Objection to Planning Application 2026/62/90484/E

Re: Proposed Use of 143 Church Lane, Gomersal, as a 5-Bed Residential Children's Care Home (Use Class C2)

Planning Objection – Professional Concerns Regarding Suitability for Children's Residential Care

Jan 26      1:50,1:100      DWG 02      -

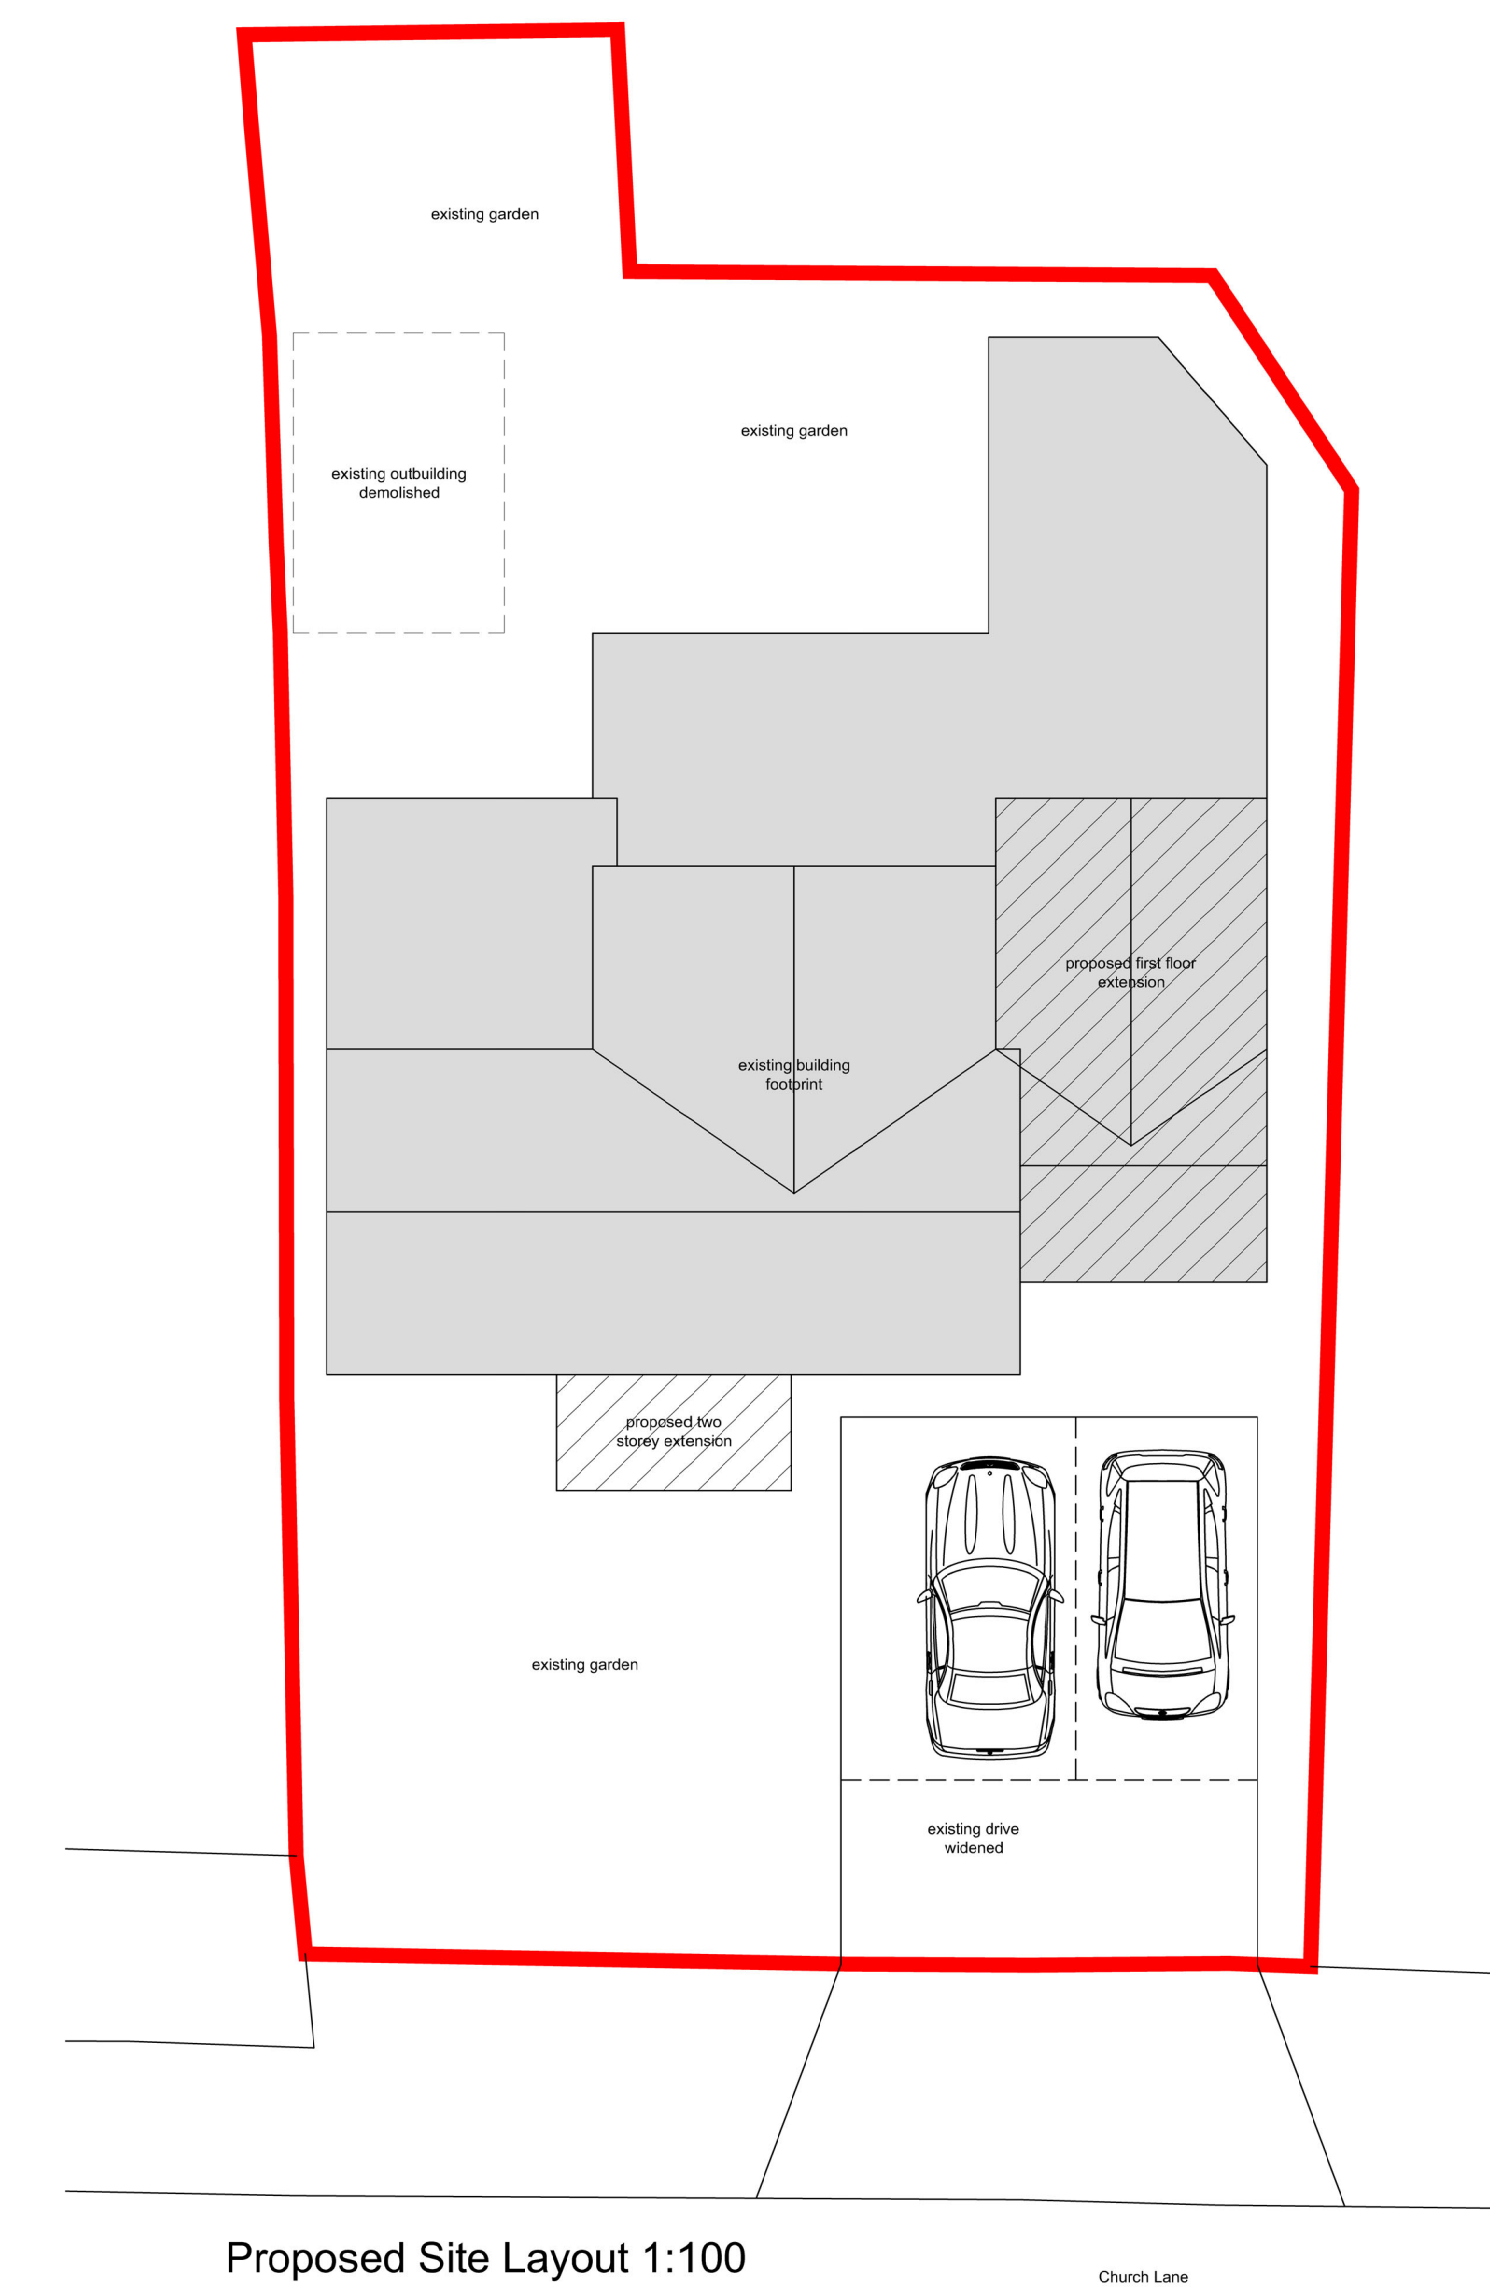
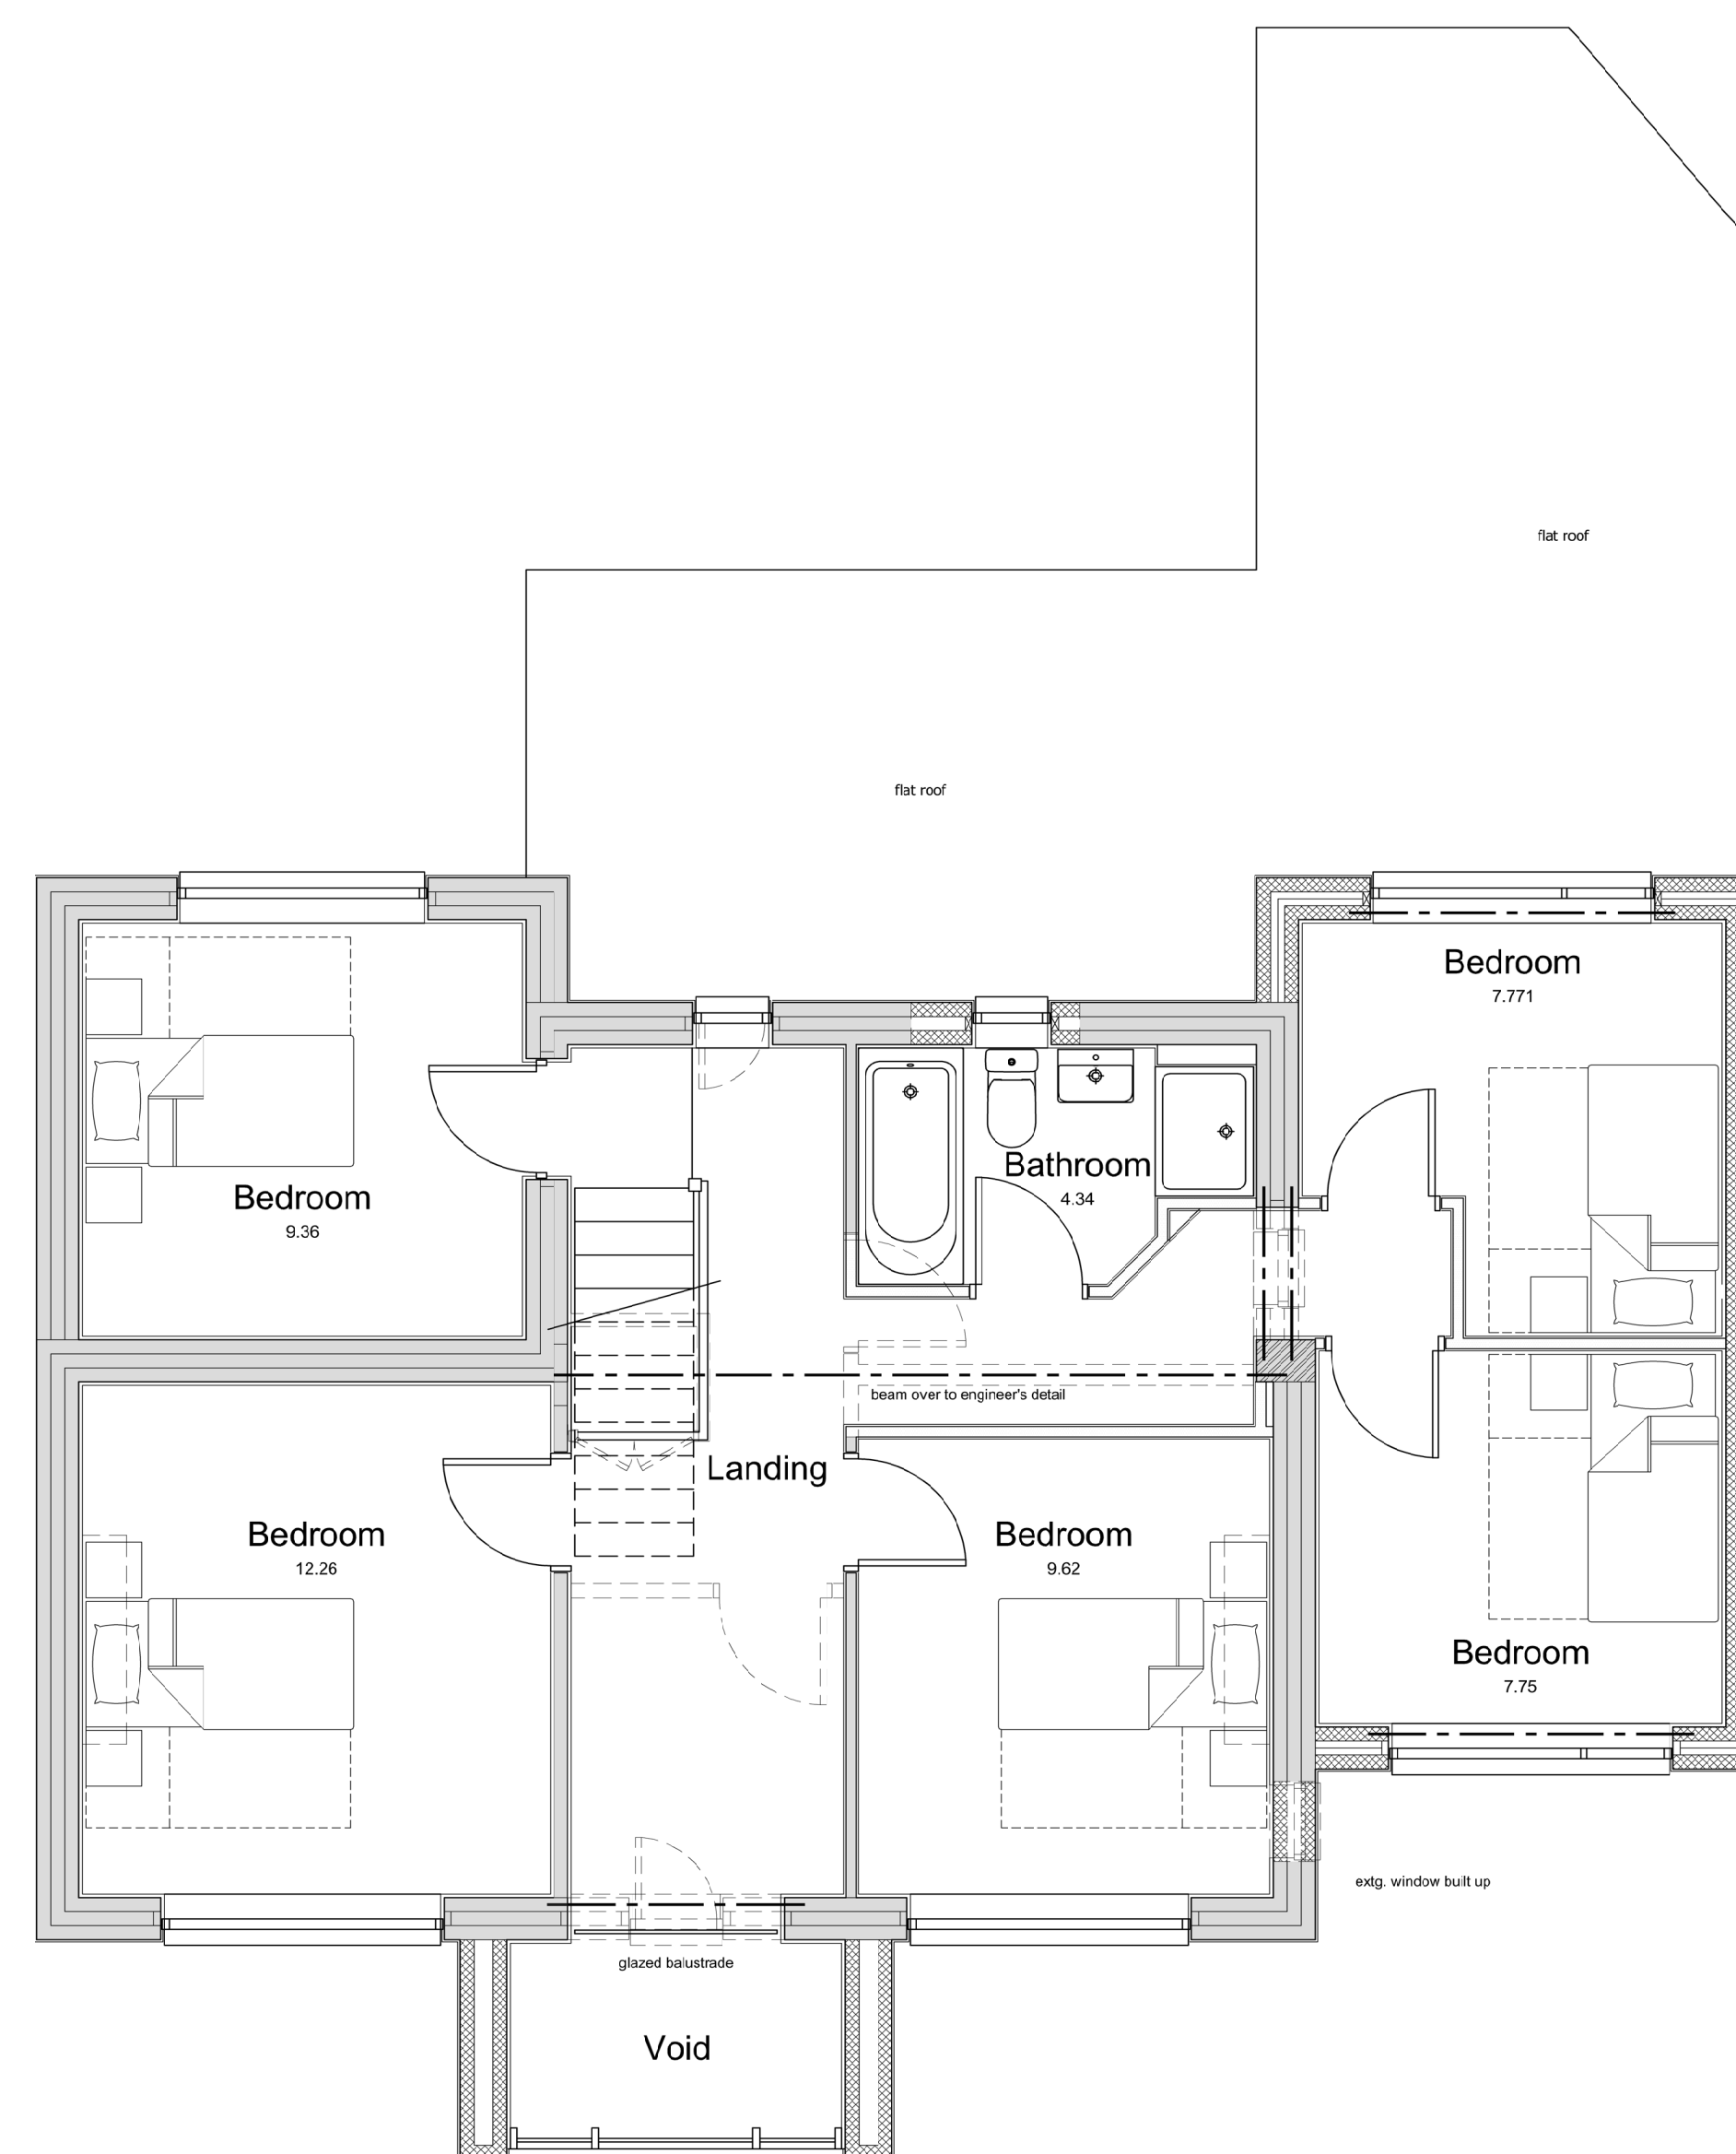
- **Outdoor space is extremely limited**, offering no safe area for regulation, therapeutic activity, or supervised play.
- The **rear elevation directly overlooks neighbouring homes**, intensifying the impact of an already constrained plot and creating privacy issues for both residents and neighbours.

The layout raises serious concerns regarding fire safety and the ability to maintain a secure environment.

- Proposed fire exits appear to lead onto a **flat roof**, creating an unsafe and easily accessible absconsion route.
- **Low boundaries** and proximity to neighbouring gardens reduce the ability to maintain a safe perimeter.
- A **bus stop directly opposite** the property provides rapid access to Leeds and Bradford, increasing absconsion risk before staff can intervene.
- Adjacent farmland contains **livestock and heavy machinery**, posing further risks should a child abscond.
